Application No: LU/112/22/PL
Site Address: 135A Wick Street Littlehampton BN17 7JY
Description of works: Extension to form 1 No studio flat at first floor level. This application is in CIL Zone 4 (Zero Rated) as flats.

Thank you for your internet representation made on 5th May 2022 which has been recorded as an objection with the comments as follows:

SCALE / 1:100 @ A3
DATE / 10.12.2015
DWG.NO / 021115/TP.02REV.C

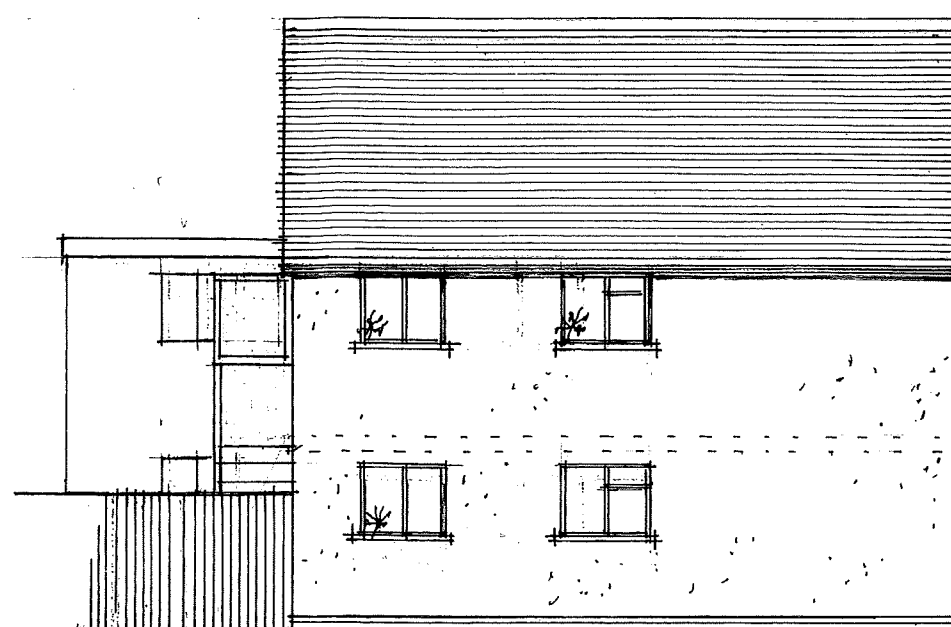
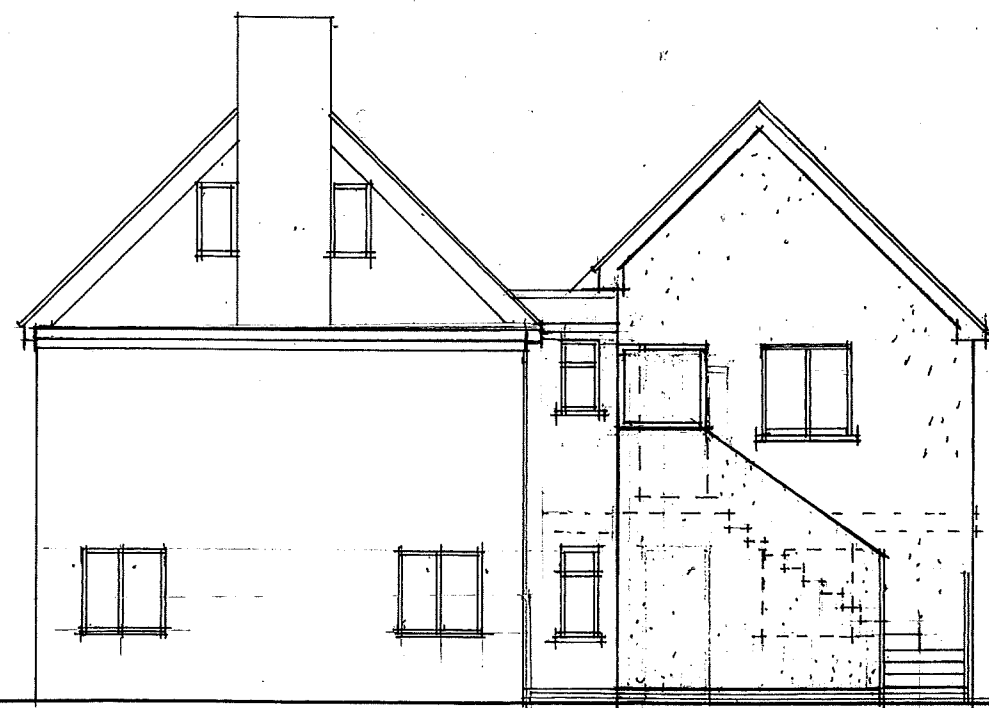
The proposed installation of an exterior staircase to access the extension would cause much noise nuisance (person/people up & down a noisy metal staircase) to us as it is adjacent to my elderly mothers bedroom in which she spends much time in my adjacent property of 2 b Courtwick Road. This staircase could also be an area which is used for smoking/drinking & unsociable behaviour because of the aforementioned lack of outdoor/amenity space.

Overshadowing & dominating my property affecting natural light.

DWG. NO / 021115/TP.01.REV.C

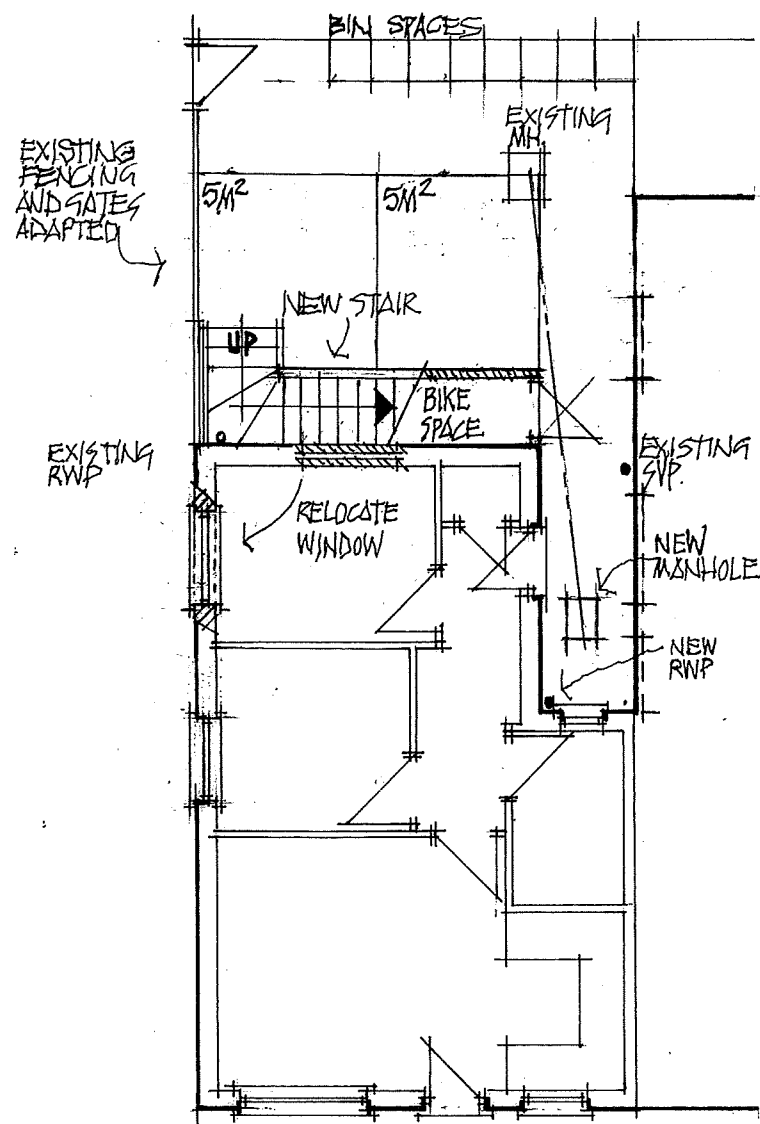
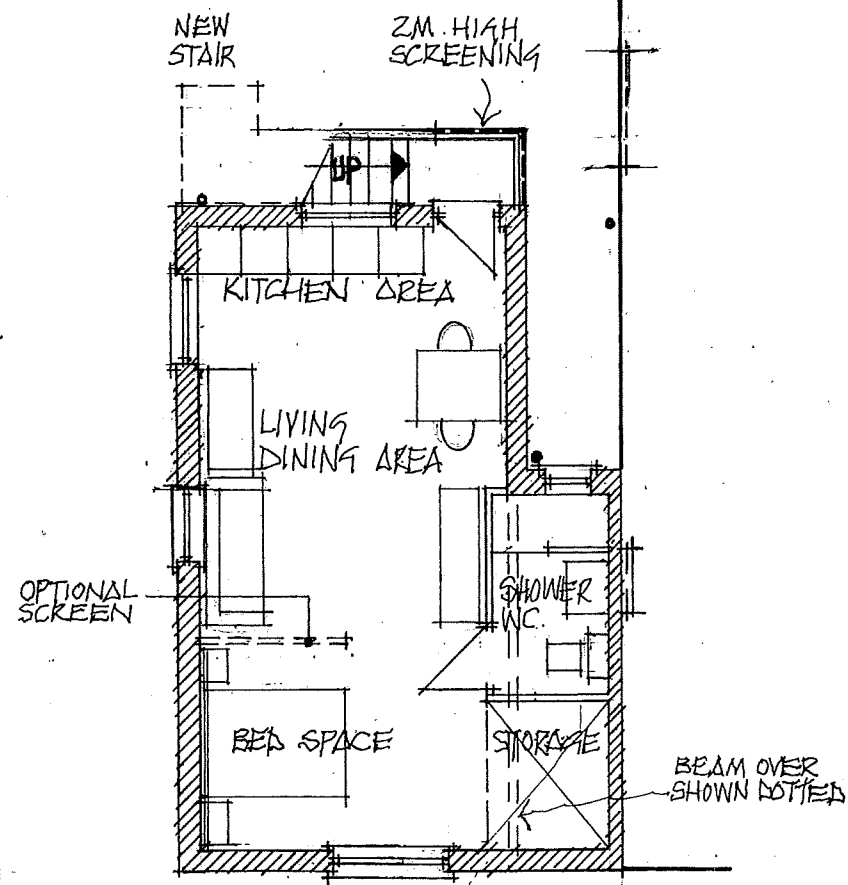
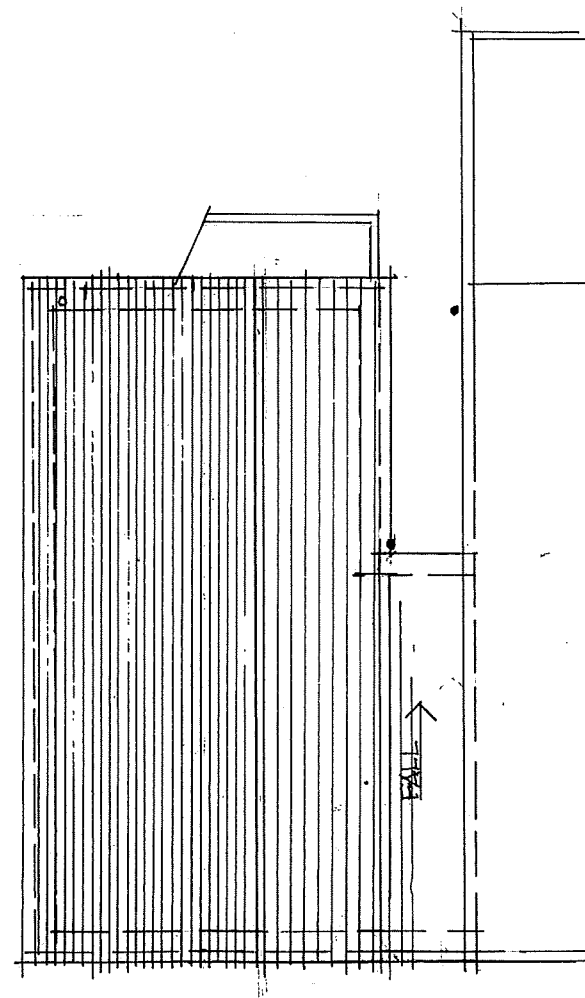
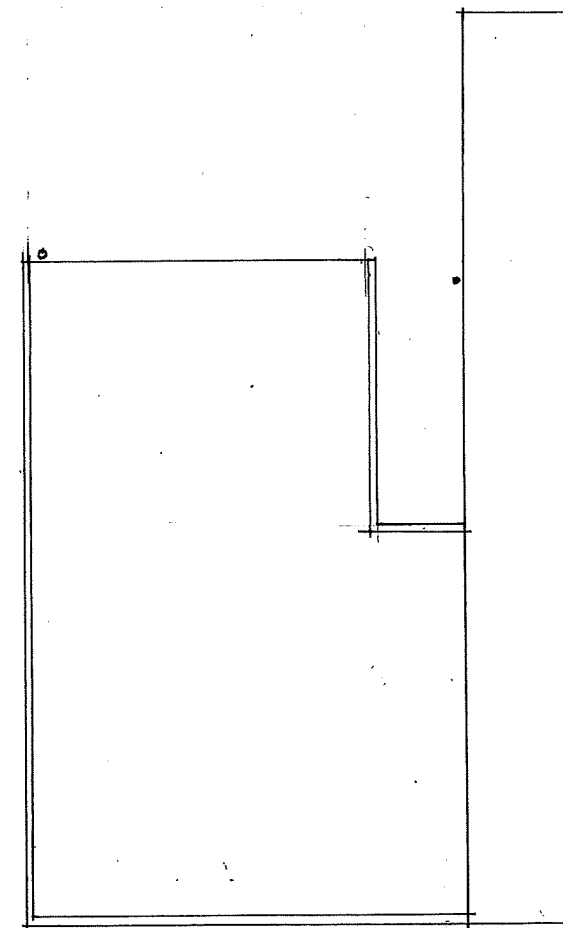
The plans do not mention where the new gate to the site is to be placed.

Contrary to the statement on the plans there is no 'on street parking.'

There is little garden area/amenity space.

Is it known if the foundations to the existing single storey building are adequate for a two storey building? If not, would it be necessary to do an exploratory excavation to ascertain this?
